From: [REDACTED]
To: [A30 Chiverton to Carland Cross](#)
Cc: [Jeremy Merrick](#)
Subject: Deadline 4 Submission from The Harvey Family, [REDACTED]
Date: 01 May 2019 15:21:06

We write in connection with the Applicant's responses to Deadline 3, specifically Document 8.9 Response to Hearing Action Points - ISH 2 on Draft DCO and the other documents mentioned therein.

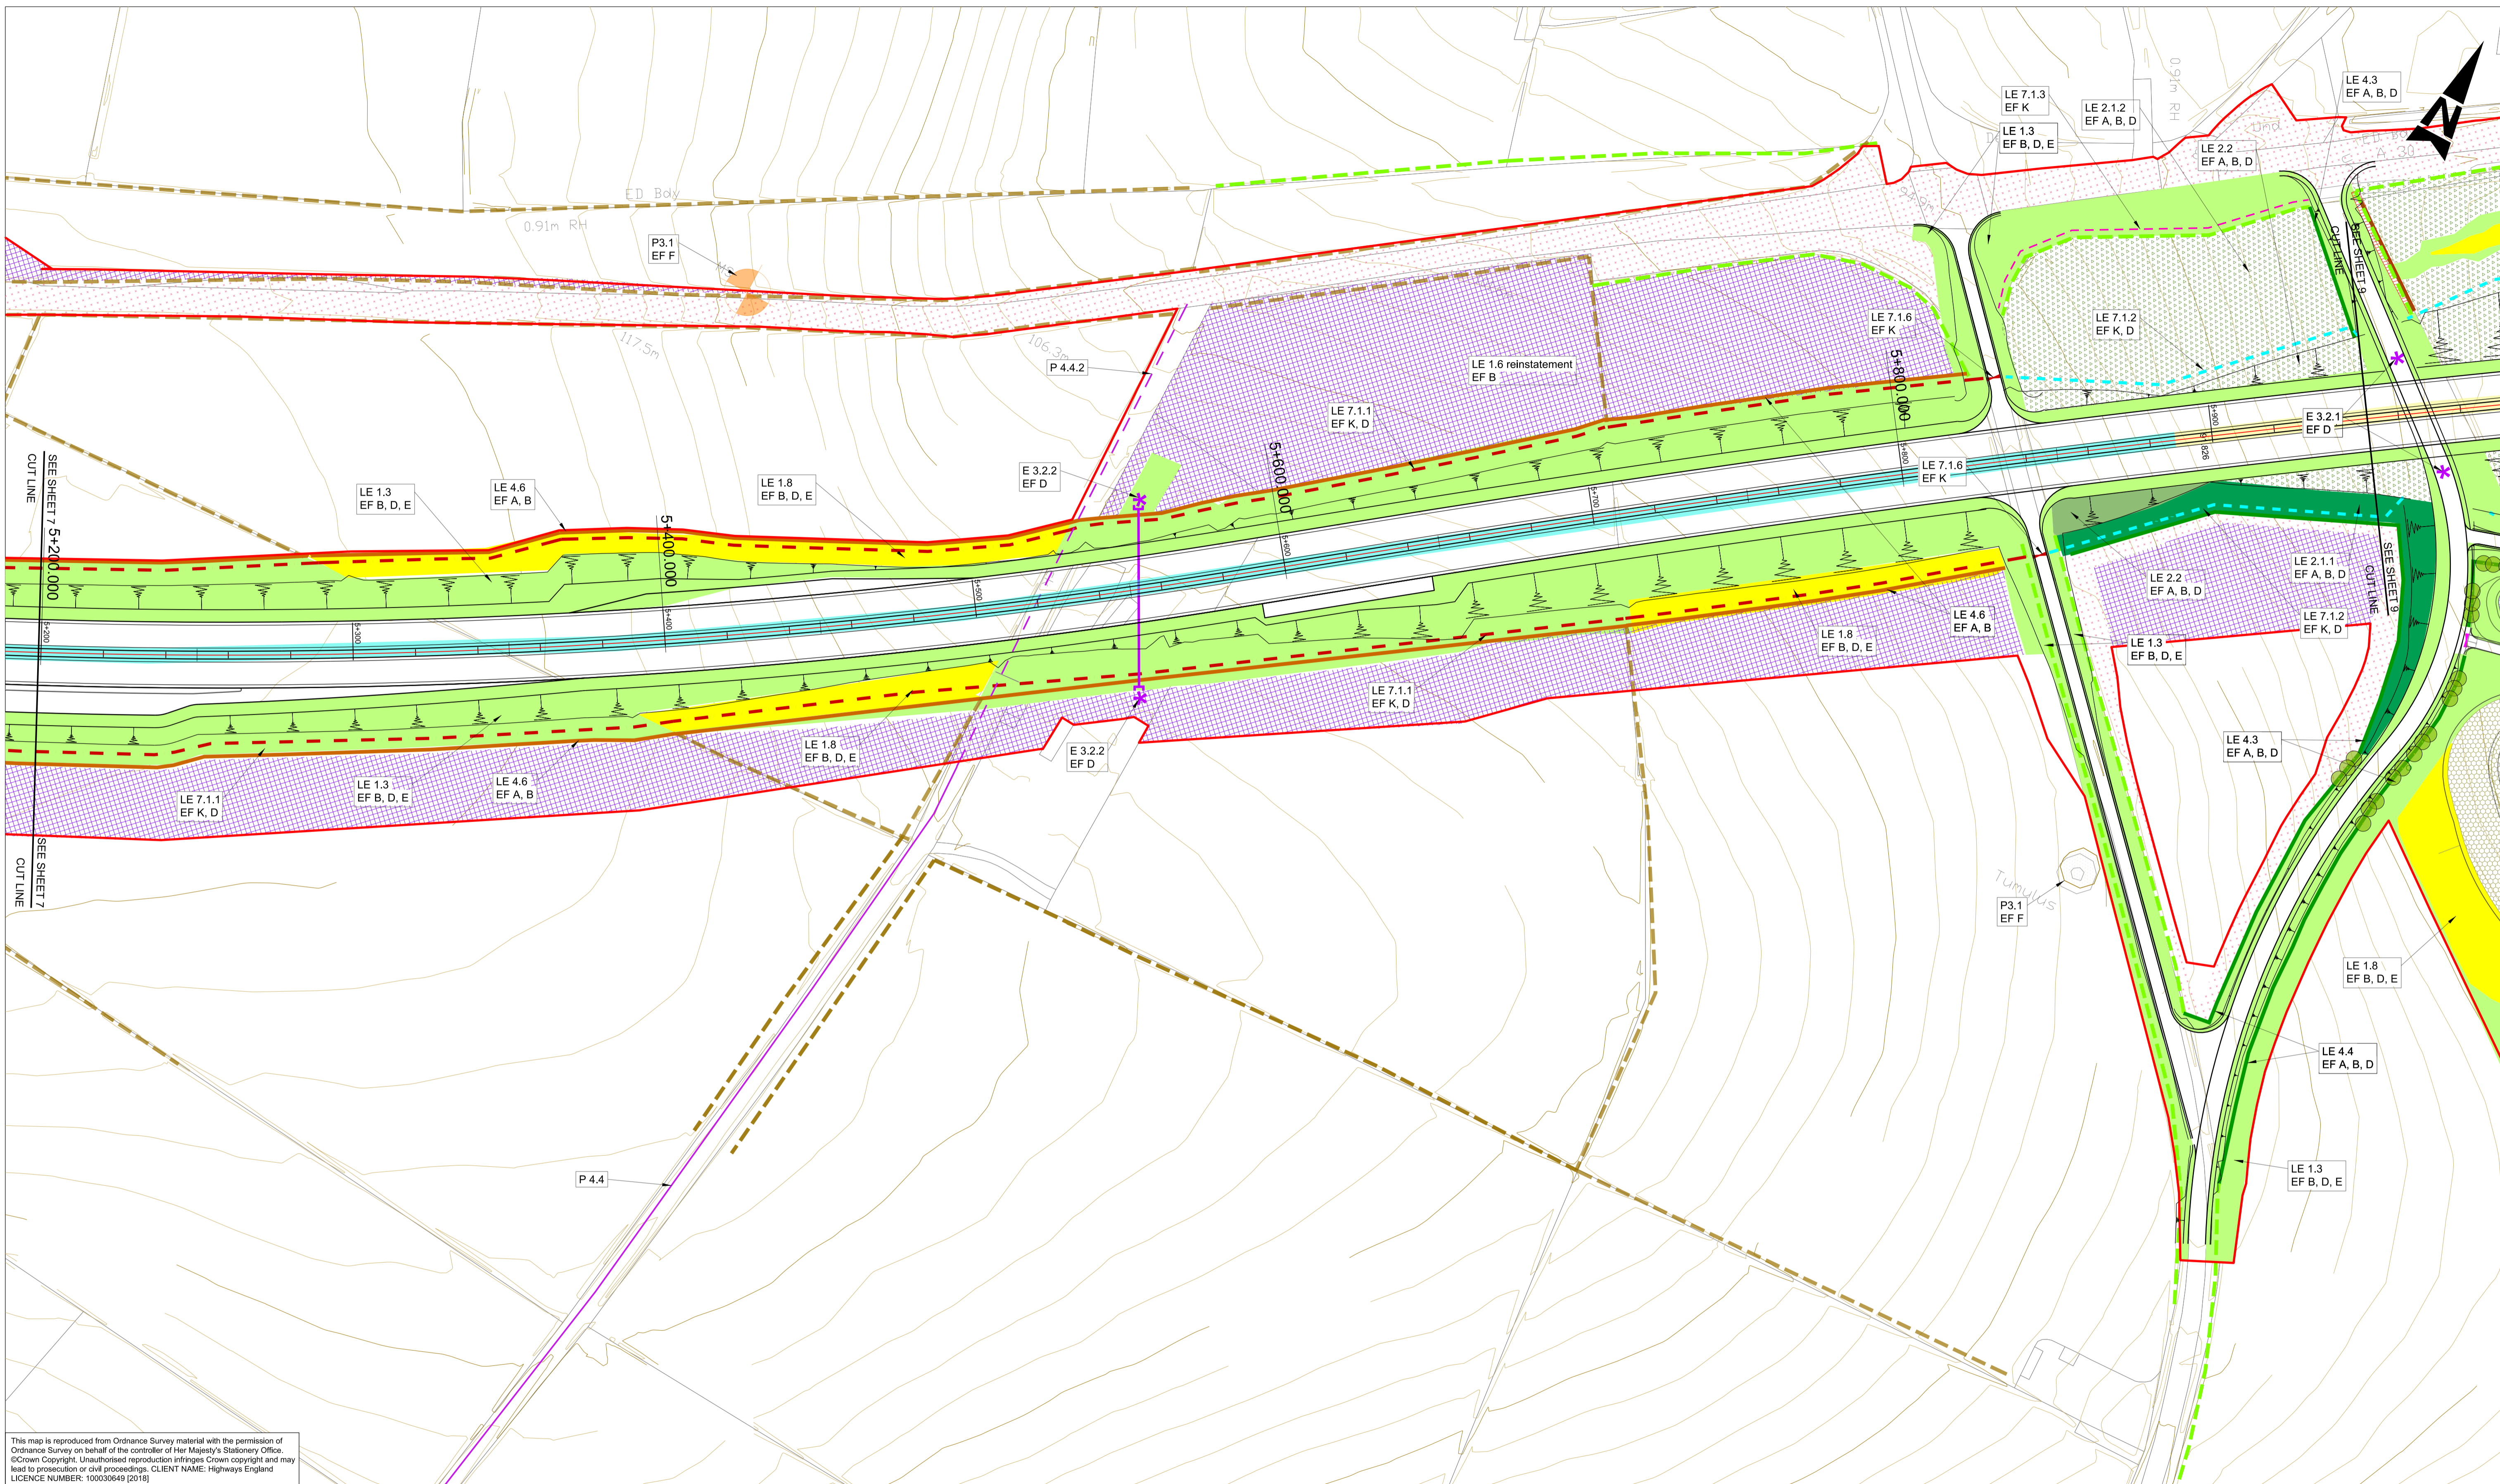
The stream is situated immediately adjacent to the boundary running between our wild flower meadow and with the attenuation pond field (Pond Field). The boundary comprises a substantial stone hedge with mature plantings (see photograph). Access between the two could only be achieved by wholesale destruction of at least part of this hedge. On sheet 6 of TREES AND HEDGEROWS TO BE REMOVED OR MANAGED APFP REGULATION 5(2)(O), there is no reference to this hedge being breached or removed, indeed virtually the entire hedge is enclosed by a black bordered box indicating, according to the key, that it contains VEGETATION TO BE RETAINED. This protection is reinforced on APP-195 6.3 ENVIRONMENTAL STATEMENT FIGURE 7.6 – ENVIRONMENTAL MASTERPLANS Sheet 15 of 20

where the red hatching extending over the stream and stone hedge highlights VEGETATION TO BE PROTECTED & RETAINED. The stream is also shown on the Environmental Masterplan as a watercourse and is again to be protected and retained. The Pond Field will have a vehicular access direct from the existing A30 across a wide highway verge. This will provide a very superior access.

Given that there is no physical connection between the Pond Field and our Wild Flower Meadow, and the applicants are not seeking to amend the protection that the hedge and vegetation enjoy, and since the applicants are not seeking to enlarge the DEVELOPMENT CONSENT ORDER BOUNDARY / LIMITS OF ORDER LAND we believe that the stream cannot be of any use in construction, useage, protection, inspection, maintenance of the attenuation pond, drainage, access or landscaping. We further believe that there would be no advantage whatsoever to the A30 Chiverton to Carland Cross improvement scheme in such permanent rights being acquired bt HE. Whilst we were, and remain willing to allow temporary usage of the stream while the attenuation pond is being built, we are not convinced that it is in the best interests of HE. We suspect the right was mooted by someone unfamiliar with the site and by reference to satellite imagery only.

We request that Schedule 5 of 3.1(D) The revised DRAFT DEVELOPMENT CONSENT ORDER be amended by deleting Plot 8/2c and the statement: "New right to construct, use, protect, inspect and maintain drainage attenuation pond no. 14, associated drainage facilities, access and landscaping". Colouring on SHEET 8 of 2.2(B) LAND PLANS (Deadline 3 version) of the stream should also be changed from blue (acquisition of permanent rights) to green (temporary acquisition), or removed altogether if the applicants agree that there is no benefit to them in acquiring the land temporarily.
